# CITY OF ALBUQUERQUE

September 25, 2019

RE: **7519 Eagle Rock NE**  
**Grading Plan**  
**Engineer's Stamp Date: 4/22/19**  
**Hydrology File: K12D003**

Based on the submittal received on 9/12/19, the Grading Plan cannot be approved until the following corrections are made:

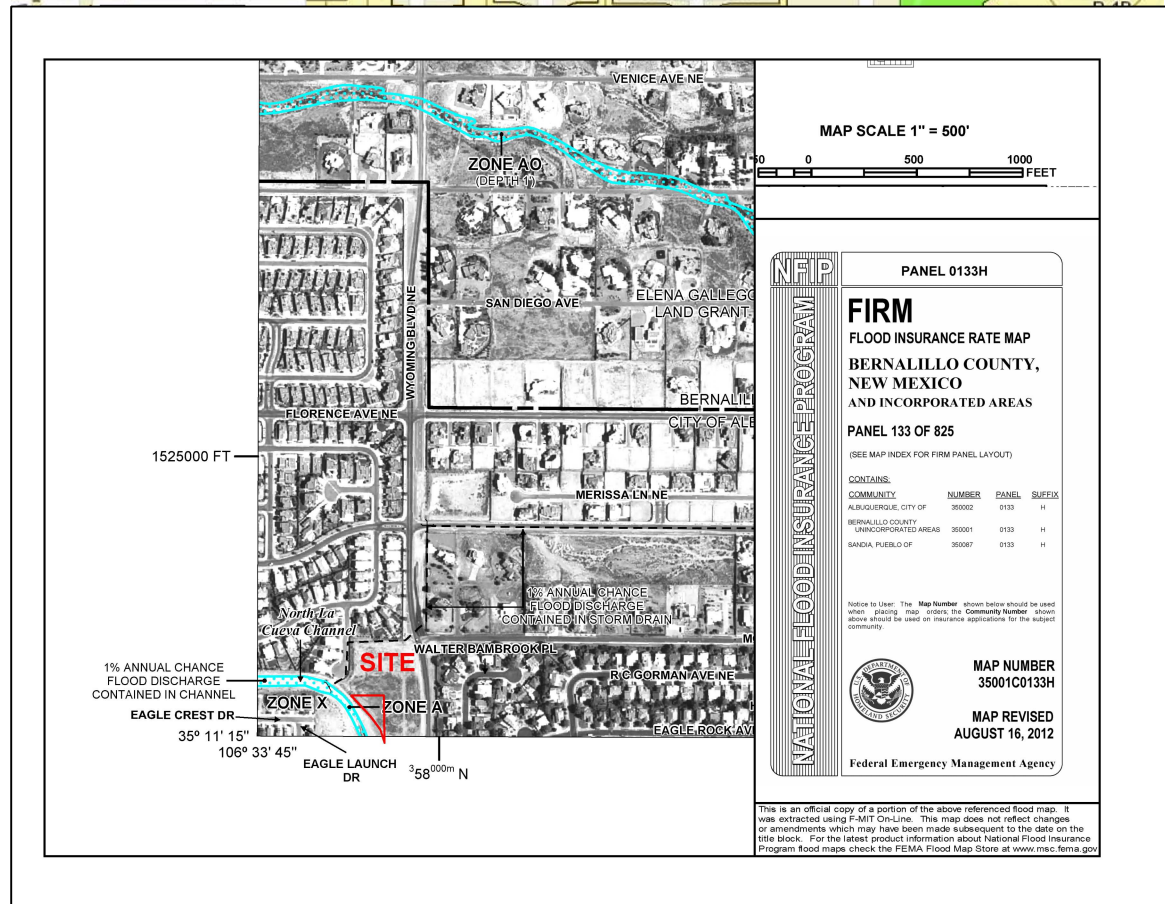
2. This site is in Precipitation Zone 3, not 2.
3. Stormwater quality (SWQ) volume should be calculated as 0.34" x impervious area, but there is no SWQ requirement for individual homes, so the SWQ retention may be removed if desired.

4. Drastically screen back or remove the image underlay. The plan is nearly illegible.
5. A digital (.pdf) submittal, emailed to [PLNDRS@cabq.gov](mailto:PLNDRS@cabq.gov) is required.

7. Show/label any proposed walls. Provide sections through all proposed walls showing property/ROW lines, existing, and proposed grades. In accordance with DPM Ch.22, section

- 5 part B, grading and wall construction near the property line may not endanger adjacent property or constrain its use.
8. The driveway appears to be graded to drain straight into the garage. Provide a means to keep drainage from entering it such as a trench drain or changing the grading.
  9. Also ensure the building is elevated 1' above surrounding grades, with swales to convey drainage to the pond. Include the spillway elevation for the riprap rundown; should be at least 1' below the finished floor elevation.
